**KIRKLEES METROPOLITAN COUNCIL  
INVESTMENT & REGENERATION SERVICE**

Reference No:	<b>2023/62/92216/W</b>
Site Address:	53, Wakefield Road, Moldgreen, Huddersfield, HD5 9AB
Description:	Erection of three storey house of multiple occupation
Recommending Officer:	William Simcock

**DECISION - REFUSE**

## **Officer Report – 2023/92216 53 Wakefield Road, Moldgreen**

DWG NO. 2318 - 01

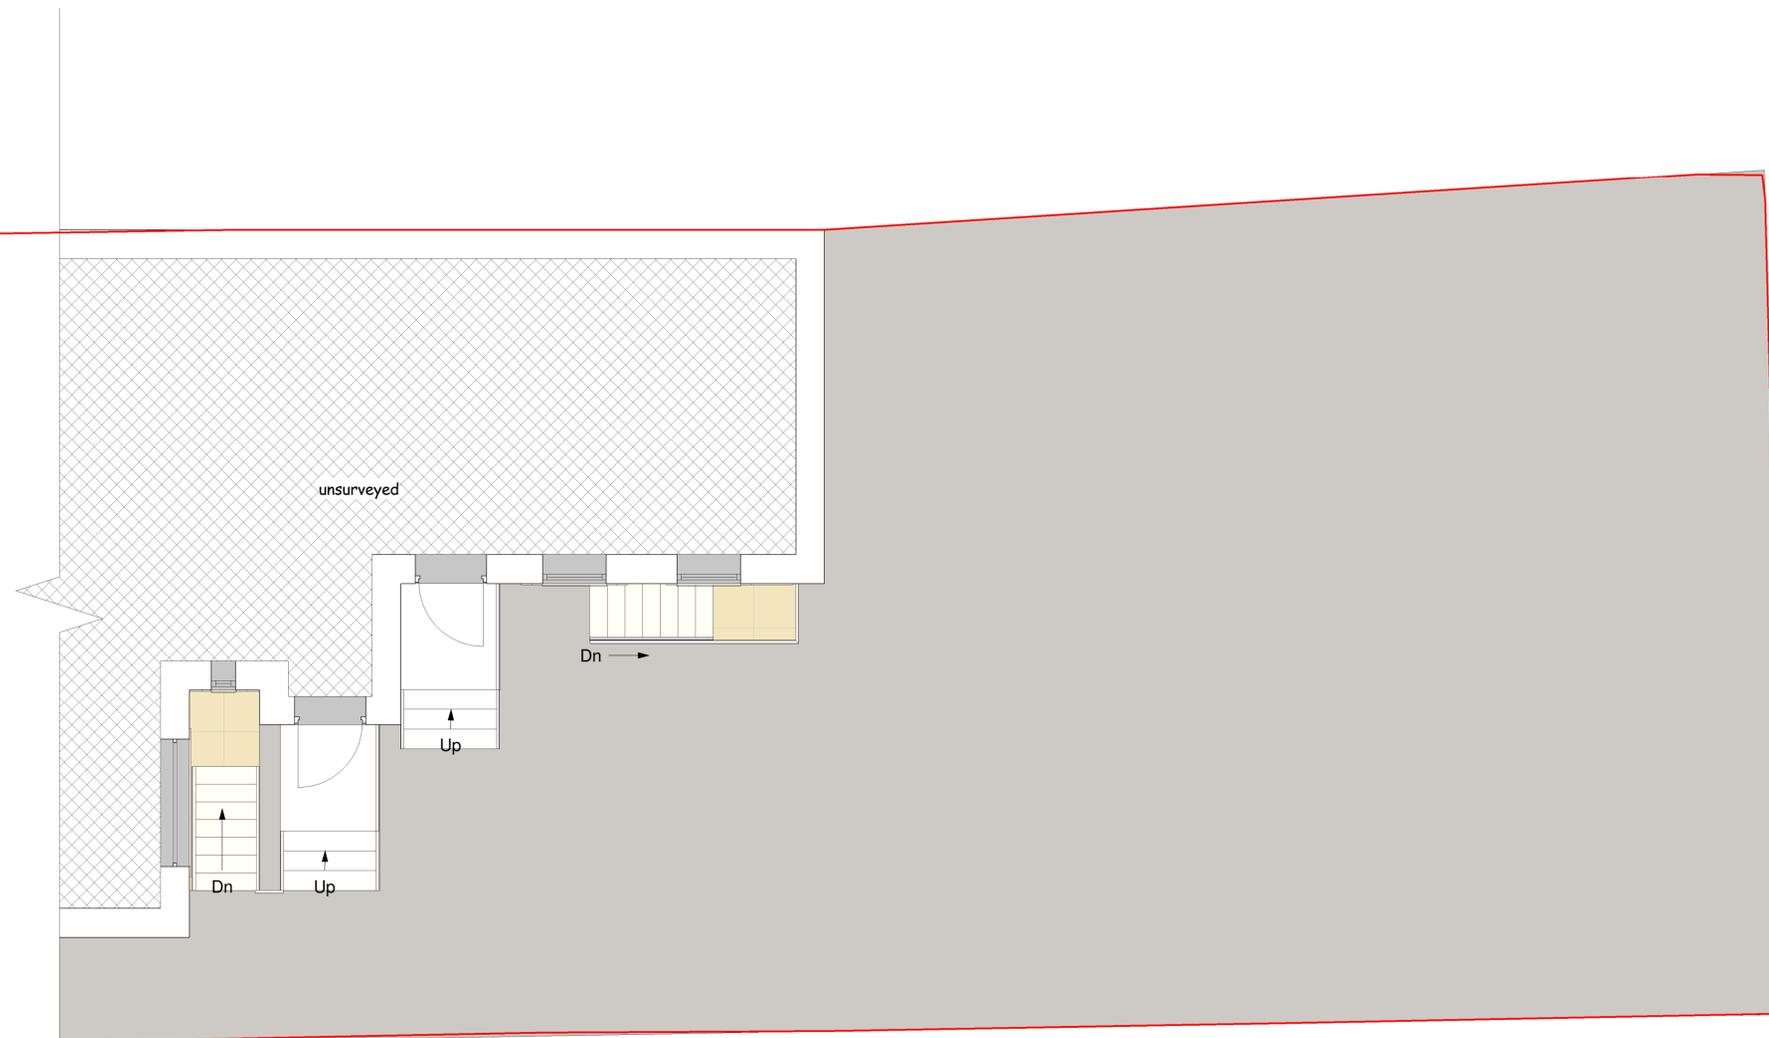
The proposed site plan indicates that there would be room to park six cars at the rear. In reality, not all of these spaces would be useable; it would be extremely difficult to steer a vehicle out of the space drawn parallel to the highway near the entrance if the others were occupied, and the use of tandem or stacked parking is not acceptable in multi-occupancy schemes as cars belonging to different occupants would have to be “shuffled” whenever someone wished to make a journey. It is doubtful that more than three spaces could be accommodated in such a way as to be useable. A practical parking layout would also have to be designed so as to leave a clear pathway for refuse bins to be put out for collection, and to allow residents easy access to the secure bicycle storage spaces. It is also unclear how the servicing arrangements for the existing businesses would be affected (the yard is used as a bin storage area for trade in addition to residential waste). These are matters that would need to be attended to (by further negotiation or by condition) if officers were generally supportive. A reduction in the number of designated spaces from six to three would leave additional space for bin storage, and for a pathway to the collection point.

DWG NO. 2318 - 02

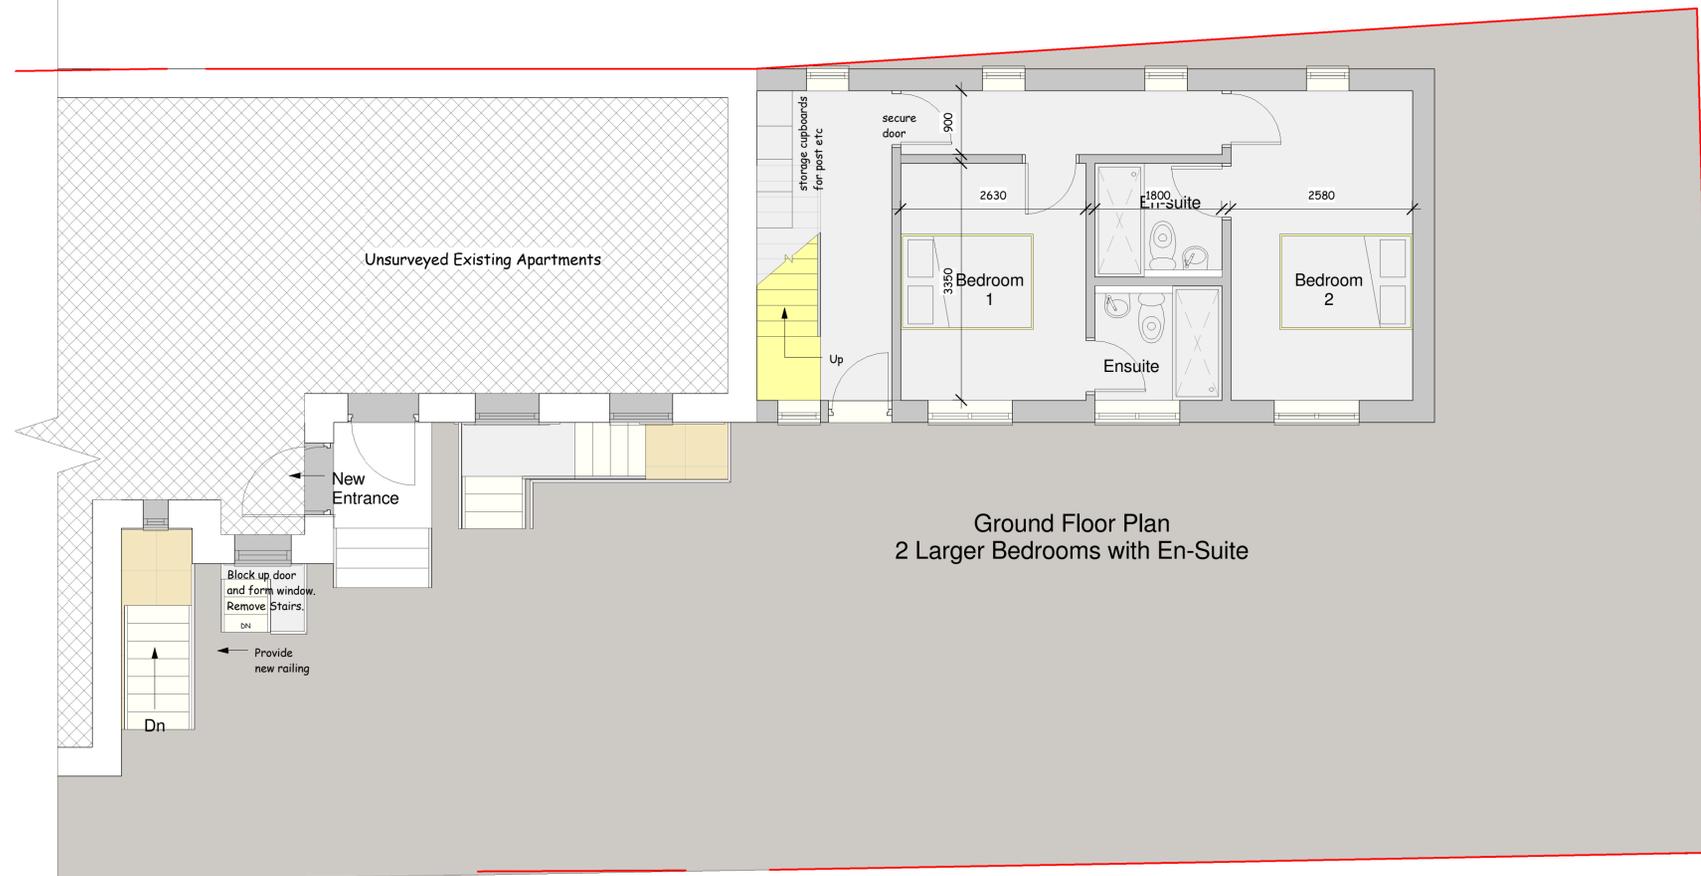
The first and second-floor windows would have an open outlook. Outlook and receipt of light for the two ground floor bedrooms – numbers 1 and 2 – would however be very poor as they would face a high stone boundary wall.

2. The proposed development, owing to the limited internal floorspace (123sqm) and the floorspace allocated to Bedroom 5 (6.5sqm) which both fall significantly short of the recommended standards for a three-storey, six-bedroom dwelling as set out in the Nationally Described Space Standards, and the poor outlook and limited natural light for Bedrooms 1 & 2, would give rise to an unacceptably low standard of amenity for future occupants, and would be contrary to the aims of Policies LP24(b) and LP52 of the Kirklees Local Plan, Principles 6 and 16 of the Housebuilders' Design Guide SPD and paragraph 135(f) of the National Planning Policy Framework.
